CITY OF ALBUQUERQUE

Re: Lupe's Cafe
1524 Central Ave. SE
Traffic Circulation Layout
Architect's Stamp 02-06-18 (K15D102)

Based upon the information provided in your submittal received 2-8-18, the above referenced plan cannot be approved for Building Permit until the following comments are addressed:

TRAFFIC CIRCULATION PLAN
CODE ANALYSIS
LOCATION MAP
SHEET
TCL

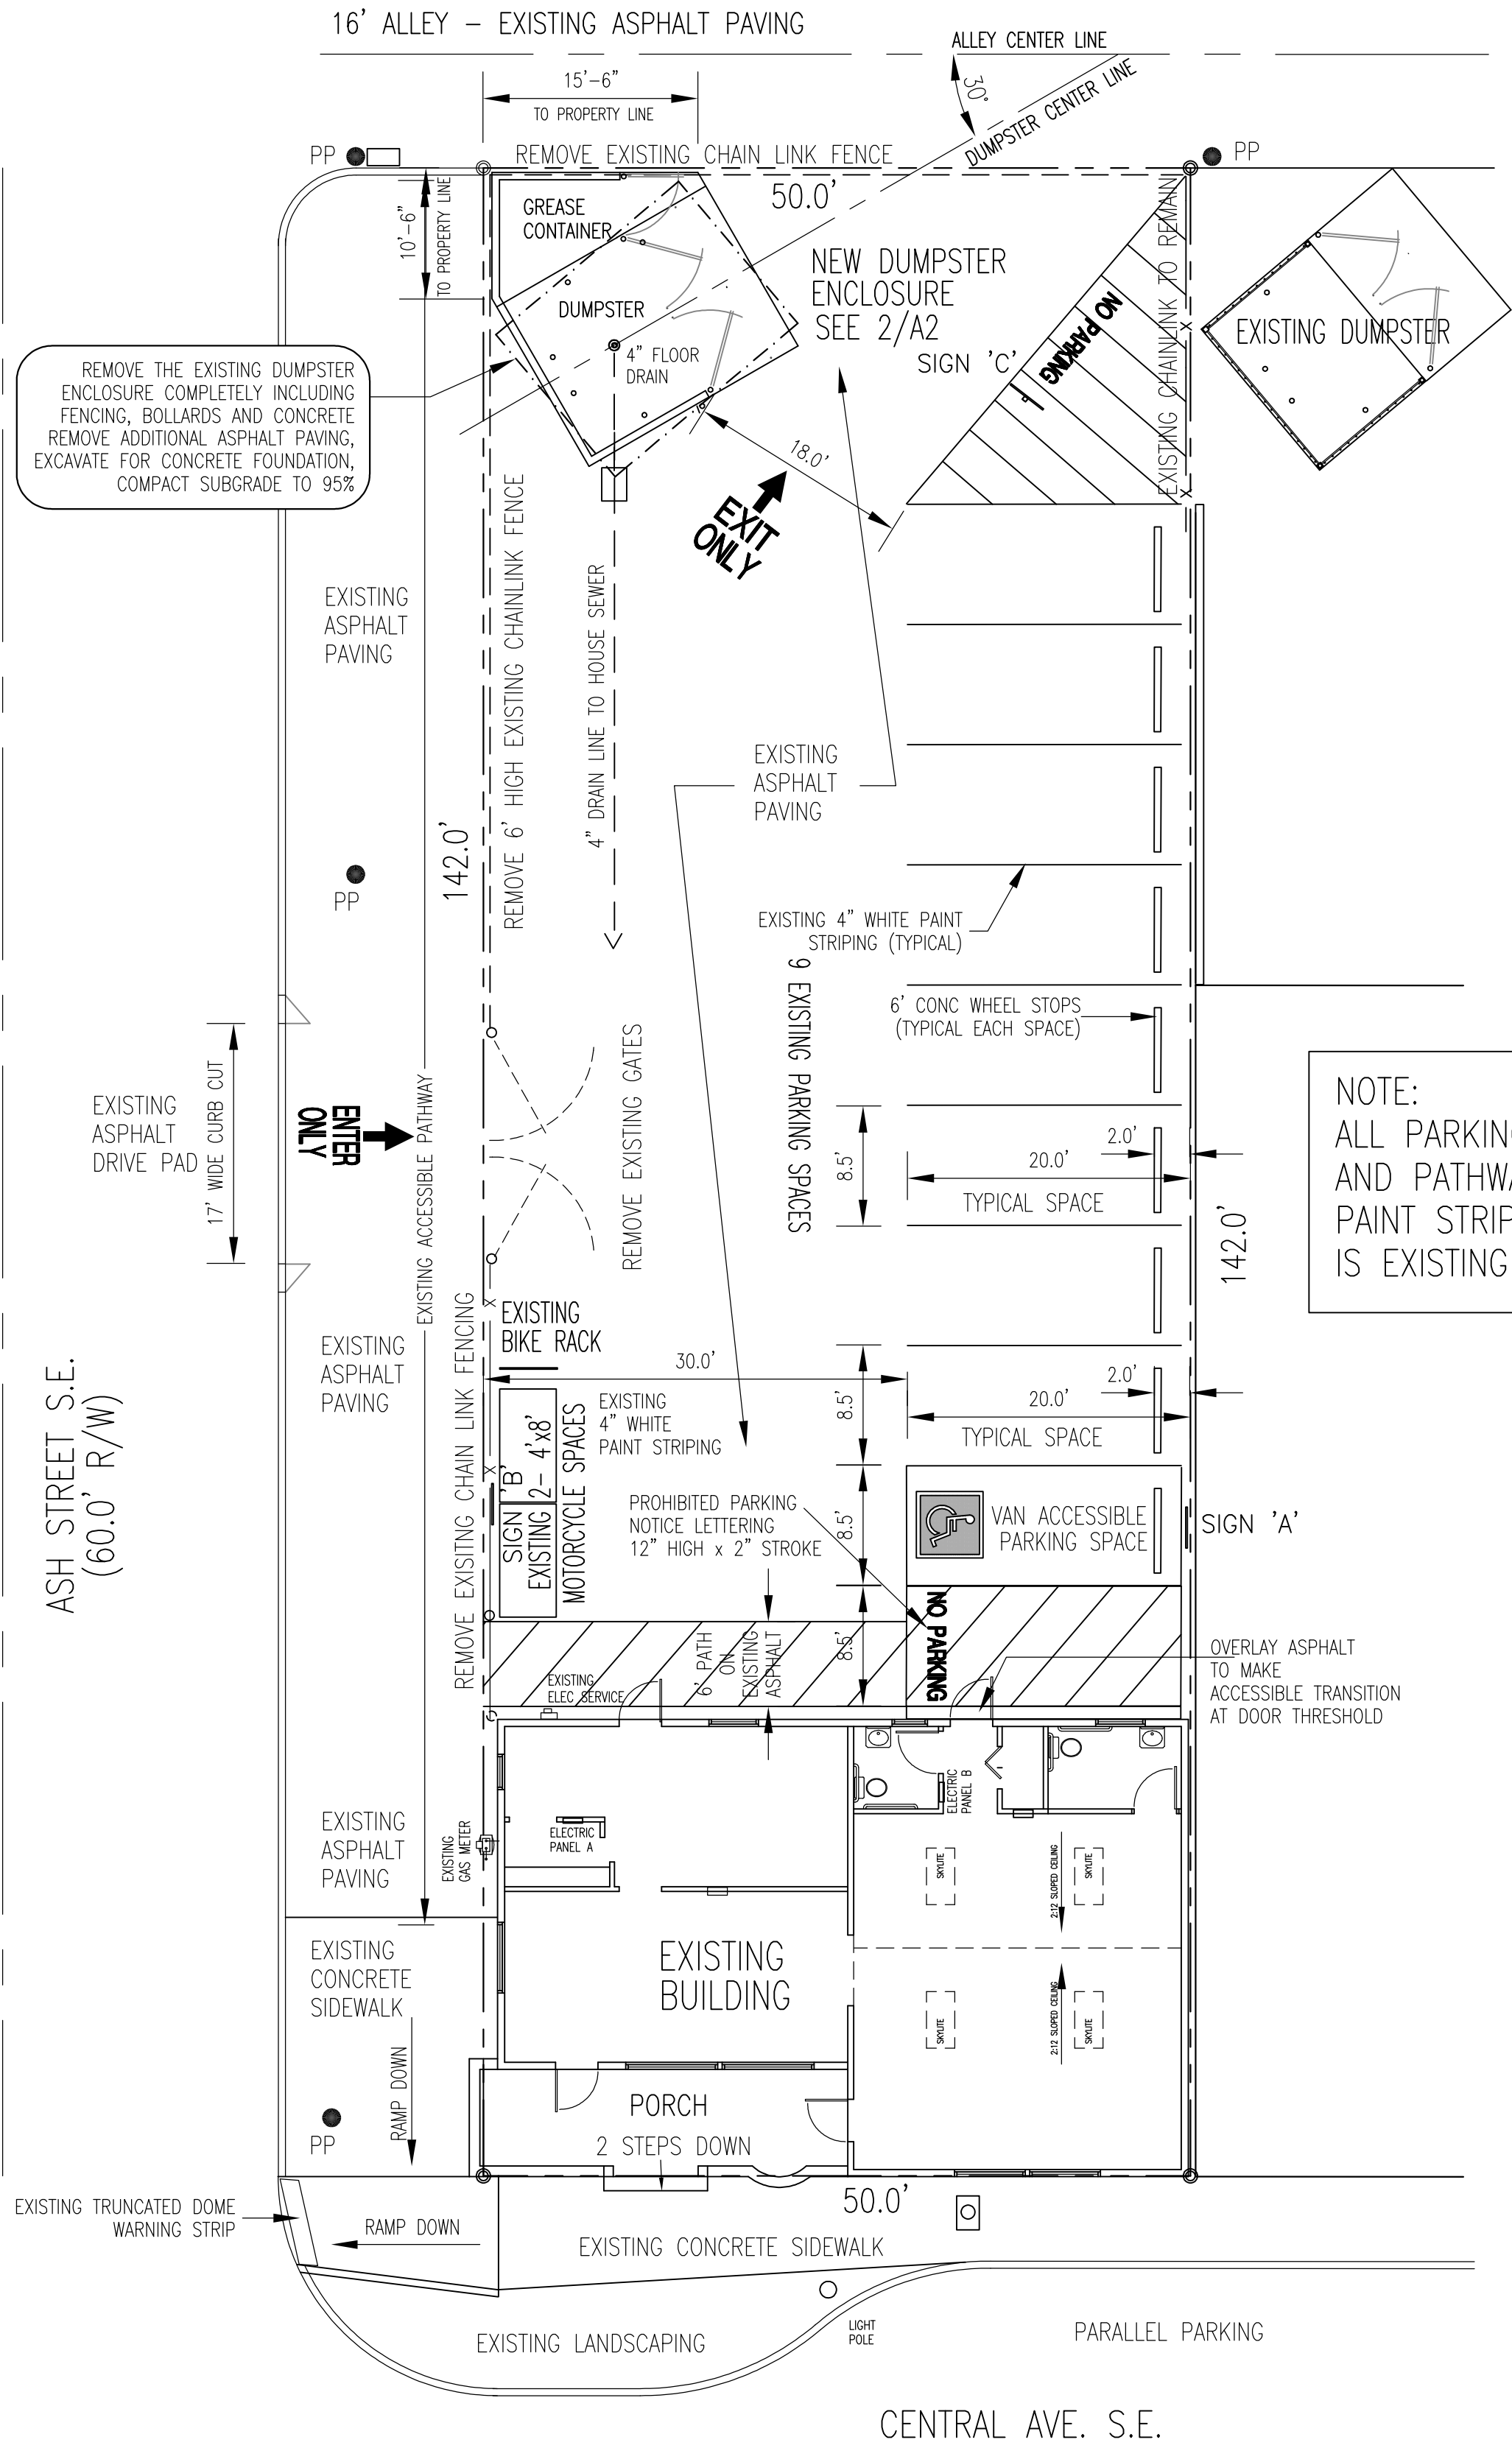
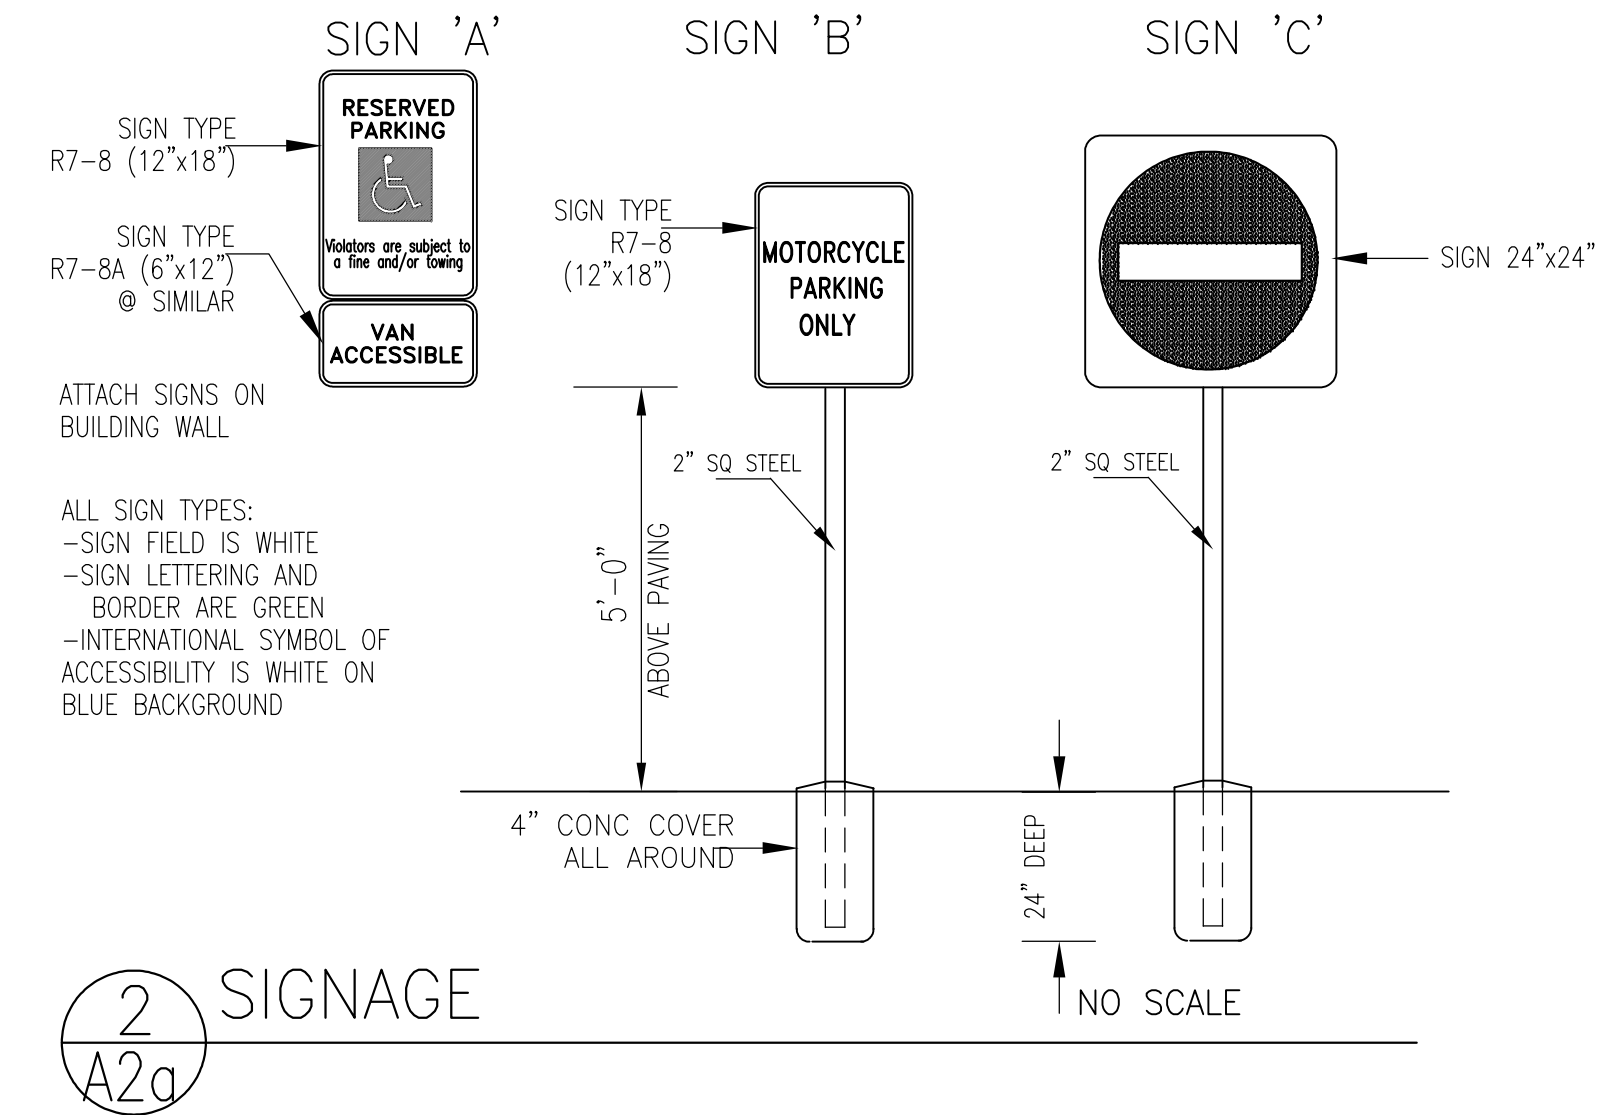
1. Please show a vicinity map showing the location of the development in relation to streets and well known landmarks.
2. The ADA access aisles shall have the words **"NO PARKING"** in capital letters, each of which shall be at least one foot high and at least two inches wide, placed at the rear of the parking space so as to be close to where an adjacent vehicle's rear tire would be placed. (66-1-4.1.B NMSA 1978)

3. Per the zoning code, a 6 ft. wide ADA accessible pedestrian pathway is required from the public sidewalk to the building entrances. Please clearly show this pathway and provide details.

4. The driveway width will not accommodate two-way traffic. One-way vehicular paths require pavement directional signage and a posted **"Do Not Enter"** sign at the point of egress. Please show detail and location of posted signs.

5. Please indicate the surface condition of the alley.
6. Provide dimensions for the motorcycle parking.
